**KIRKLEES METROPOLITAN COUNCIL  
INVESTMENT & REGENERATION SERVICE**

Reference No:	<b>2024/44/91923/E</b>
Site Address:	adj, 9a, High Street, Birstall, Batley, WF17 9ES
Description:	Discharge conditions 3-7, 9, 11, 12 on previous permission 2023/90918 for erection of detached dwelling (within a Conservation Area)
Recommending Officer:	Nina Sayers

**DECISION – Discharge of Conditions – Split Decision**

## Officer Report

Revision History			
Rev/ID	Ch/d	Change Name	Date
Proposed New Build Bungalow 9A High Street Birstall WF17 9ES			
PROPOSED SITE PLAN - 1:200			
Drawing Status PLANNING APPLICATION			
Modified by TT		Date July 2024	
Checked by TT		Date July 2024	
Drawing Scale at A1 1:200		Revision -

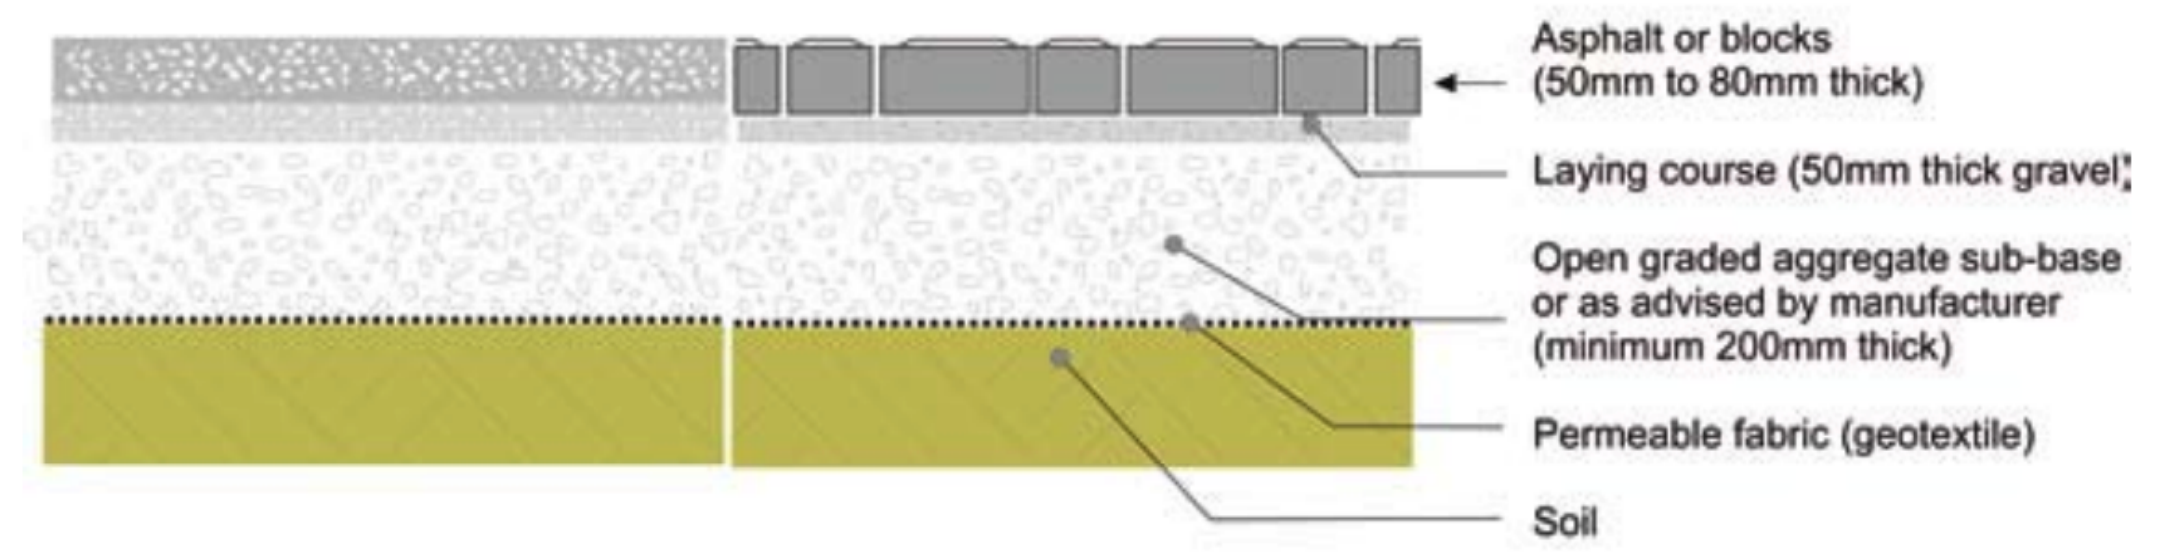
The applicant has submitted a Proposed Site Plan '(PL)002' in support of the discharge of condition 3. The submitted plan includes detail and photographs of the proposed materials which are as follows:

- Walling – 140mm tumbled stone, regular coursing
- Roofing – concrete interlocking (photograph shows black)

The proposed details are considered to be in keeping with the existing development within the area and as such are appropriate for the purposes of discharging condition 3. The development shall be carried out in accordance with the approved details and retained as such.

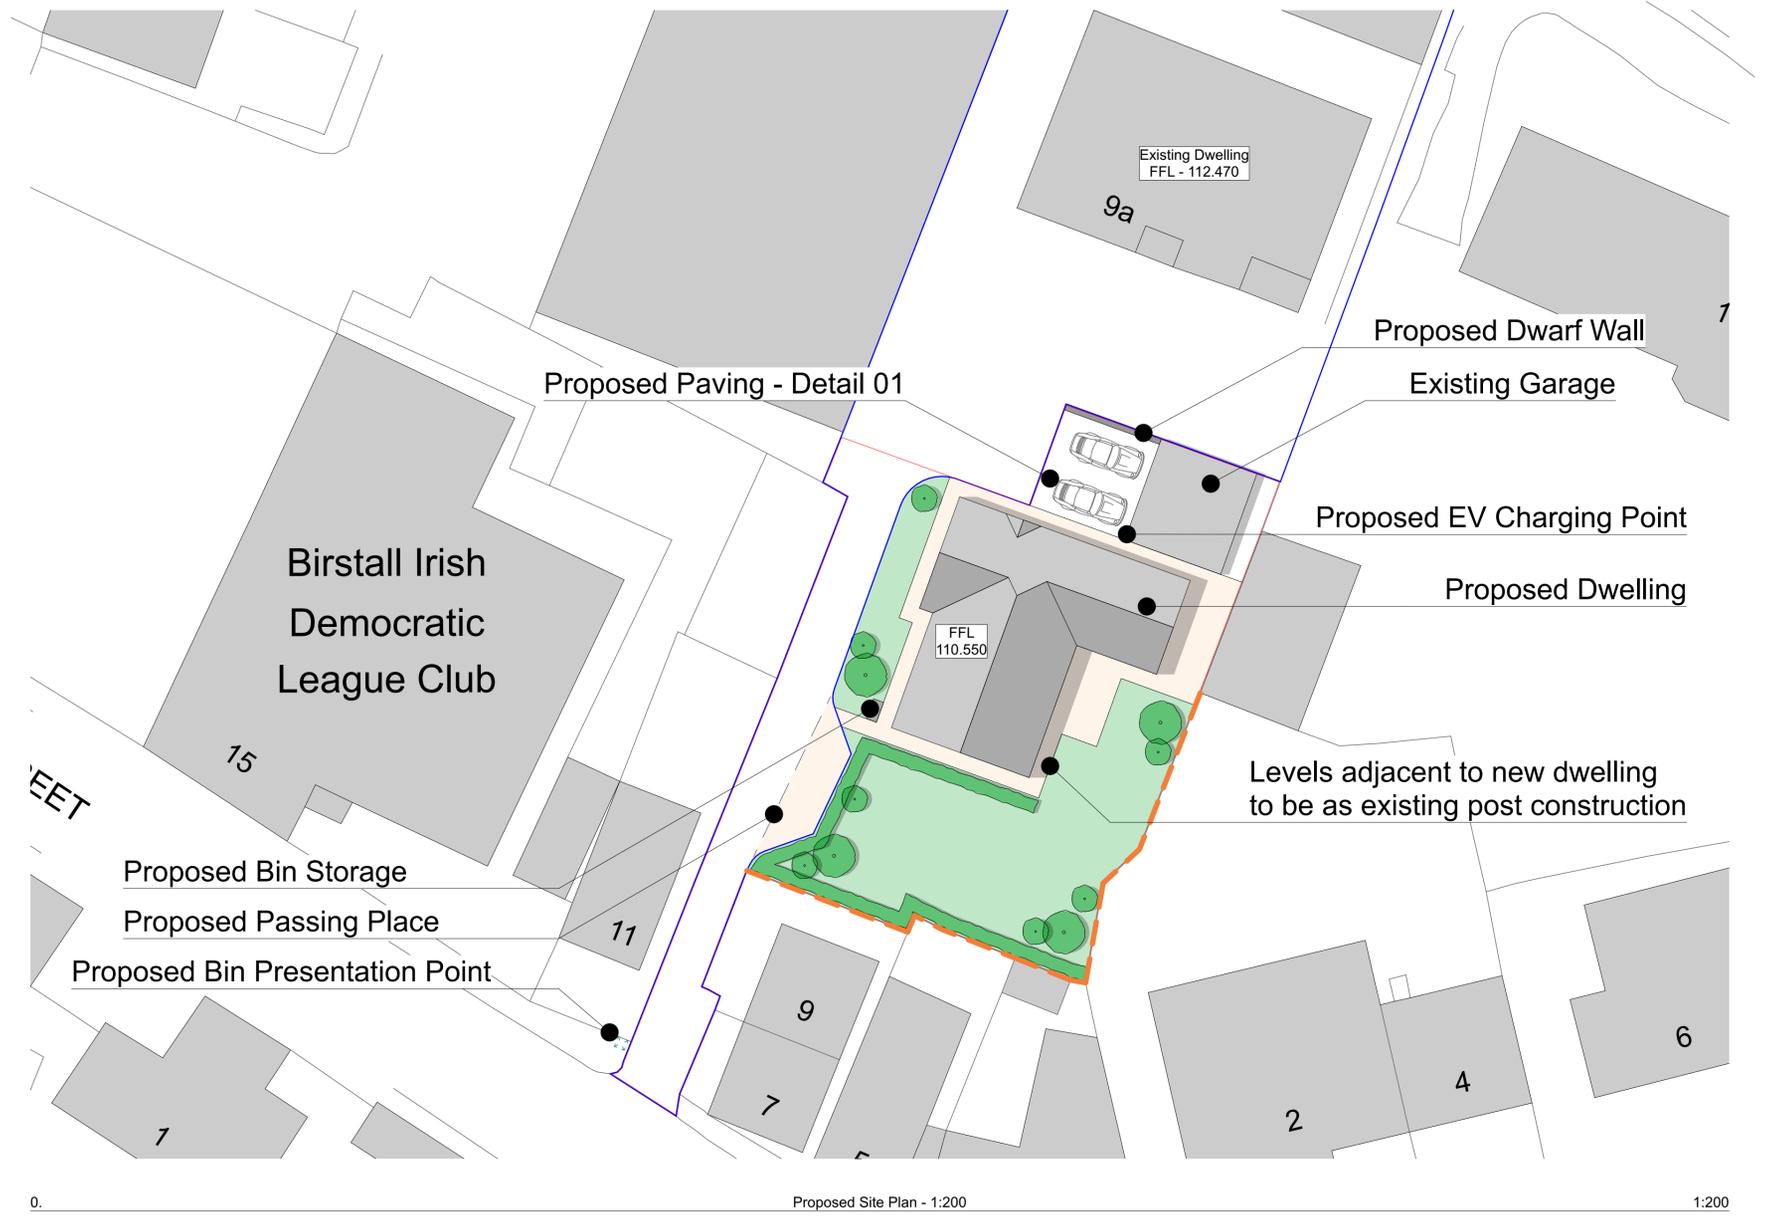
The applicant has provided a site plan ref: (PL)002A Rev.A which shows the location of bin storage adjacent to the proposed dwelling and this is considered an appropriate location. The plan also shows a bin collection point adjacent to High Street. Whilst it is noted that the bin store would be on the pavement, it relates to a wider section of pavement and it is noted that anywhere along the access road to the proposed dwelling would likely interfere with access. Therefore, the proposed collection point is considered acceptable and KC Waste Strategy raised no objections. The proposed bin collection was initially proposed adjacent to no.7 High Street however officers requested this was changed as it would block the access to no.7.

The detail submitted on site plan ref: (PL)002A Rev.A is therefore considered acceptable for the purposes of discharging condition 7. The approved details shall be provided before first occupation and shall be retained thereafter.

The applicant has submitted a Proposed Site Plan '(PL)002 Rev.A' in support of the discharge of condition 11. It details a vertical timber fencing panel along the southern and eastern boundary of the site which would be 1.8m in height. This would be in keeping with the existing fencing at no.9 and is considered acceptable for the purposes of discharging condition 11. The development shall thereafter be completed in accordance with the approved details before the dwelling is first brought into use and thereafter retained.
